From: Claire Potts <Claire.Potts@arun.gov.uk>
Sent: 08 October 2019 16:22
To: Planning.Responses <Planning.Responses@arun.gov.uk>
Subject: FW: BE/42/19/DOC Oldlands Farm
Importance: High

From: David Easton [<mailto:David.Easton@arun.gov.uk>]
Sent: 04 October 2019 09:58
To: Daniel Wheelwright
Cc: Claire Potts
Subject: BE/42/19/DOC Oldlands Farm

I have received the below comments from our drainage engineers confirm that the only outstanding matter is point (3) below.

- DO NOT SCALE FROM THIS DRAWING.
- ALL DIMENSIONS ARE IN MM U.N.O.
- THIS DRAWING IS TO BE READ IN CONJUNCTION WITH ALL ARCHITECTS & ENGINEERS DRAWINGS & SPECIFICATIONS.
- MANHOLE TO BE CONSTRUCTED IN ACCORDANCE WITH WSCC STANDARD DETAIL S278/38/14 - VORTEX FLOW CONTROL

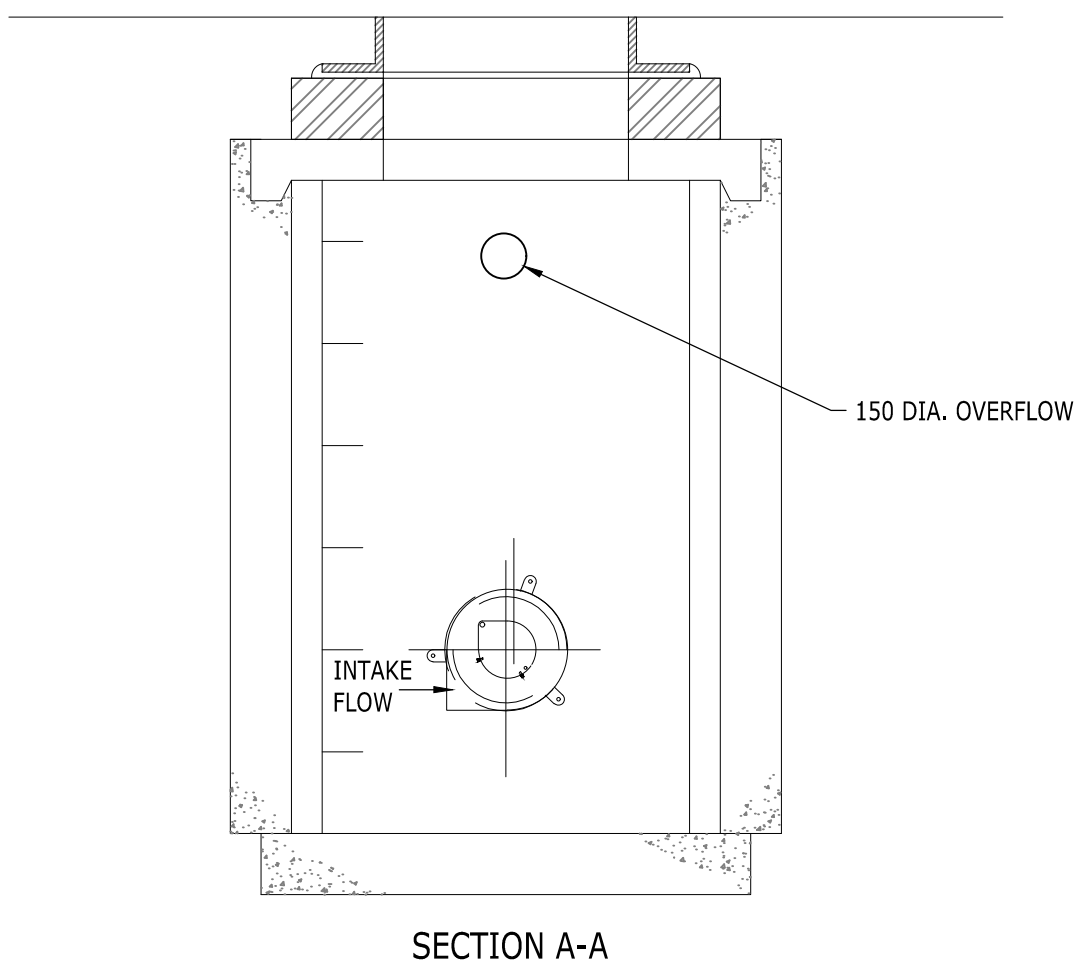
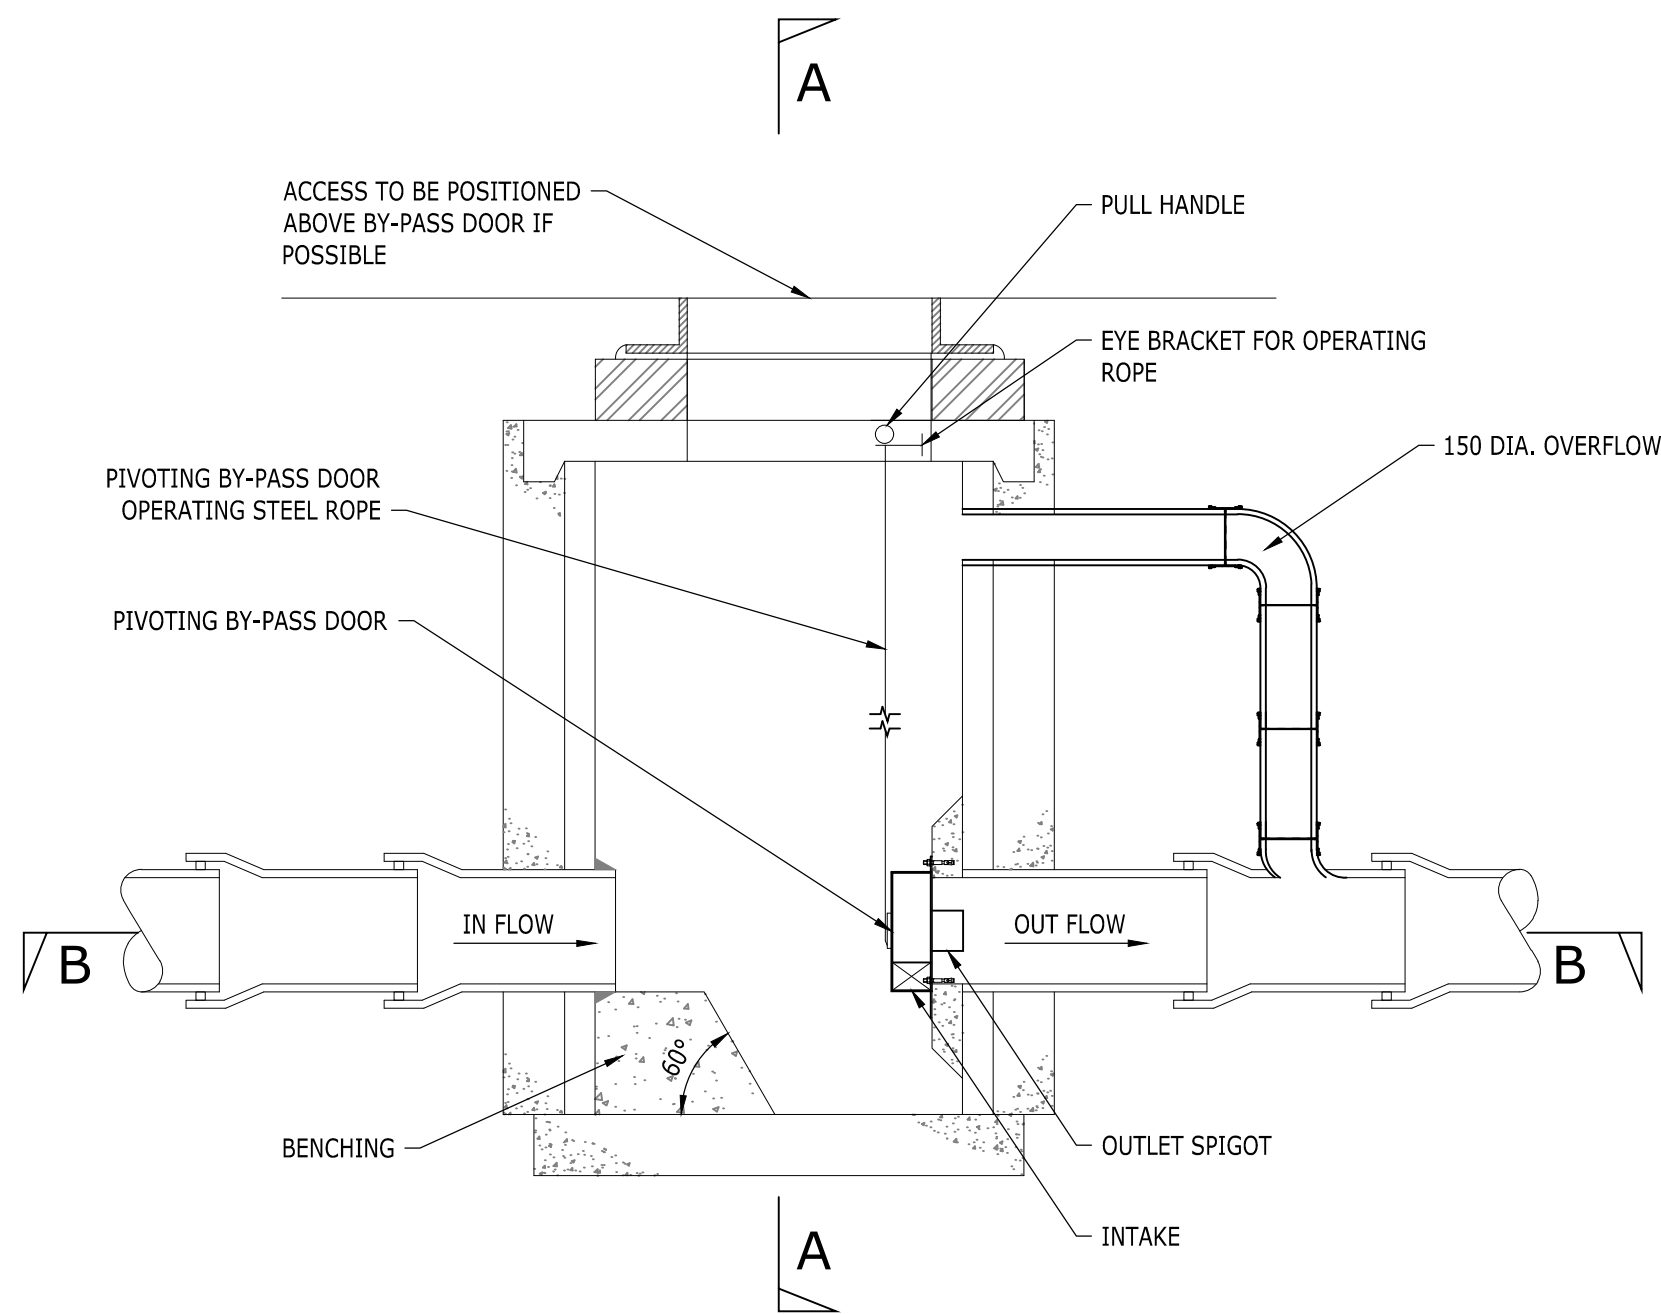
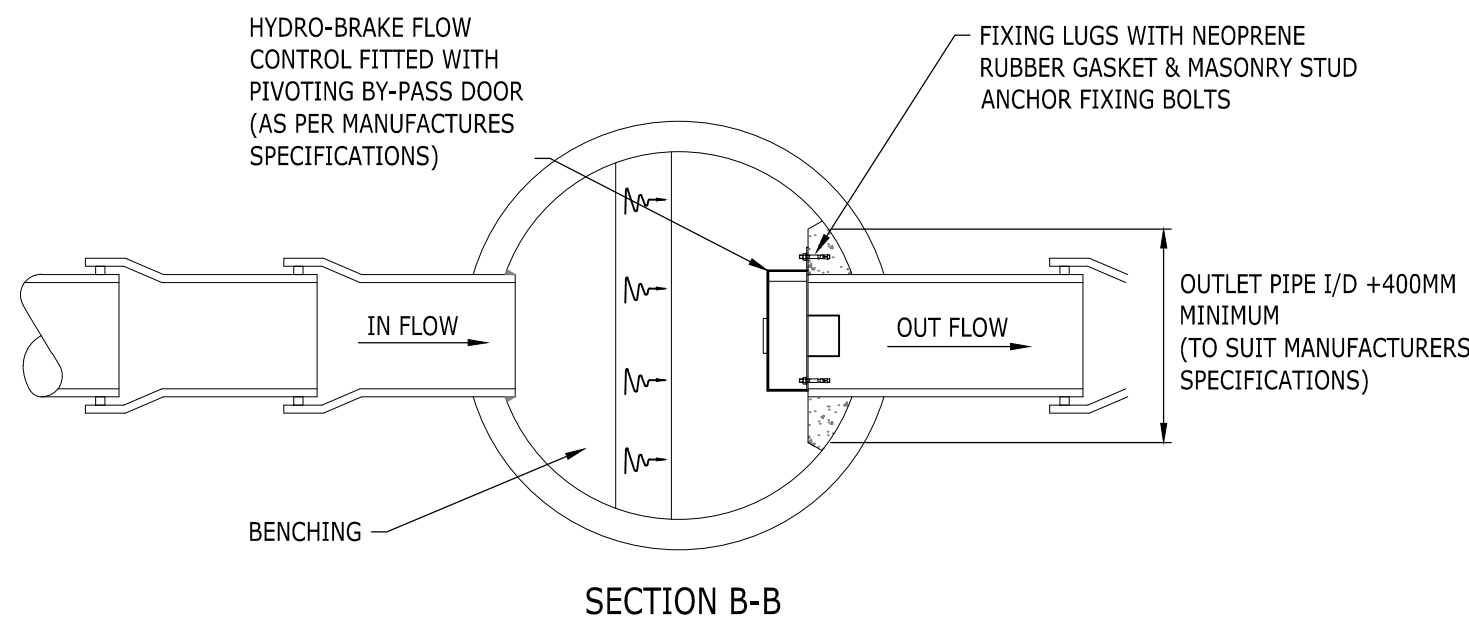
3. ~~Construction details for hydrobrake chambers need to be site specific as we need to review proposed elevations of overflows, etc.~~

~~Following remodelling no new hydrobrake chambers required, hence no detail required. Only the unit will need to be replaced in existing manhole to ensure restriction to 8.8l/s rather than 5l/s. No changes to existing manhole construction. Please provide as built detail then. As stated, we need to review elevations of overflows against calculations to ensure that flood risk is not being increased elsewhere.~~

On point 3, we confirm that the chamber was built in accordance with WSCC standards (see drawing 5278/38/14 Rev A of the attached). I would be grateful if discharge of these final conditions can now be confirmed.
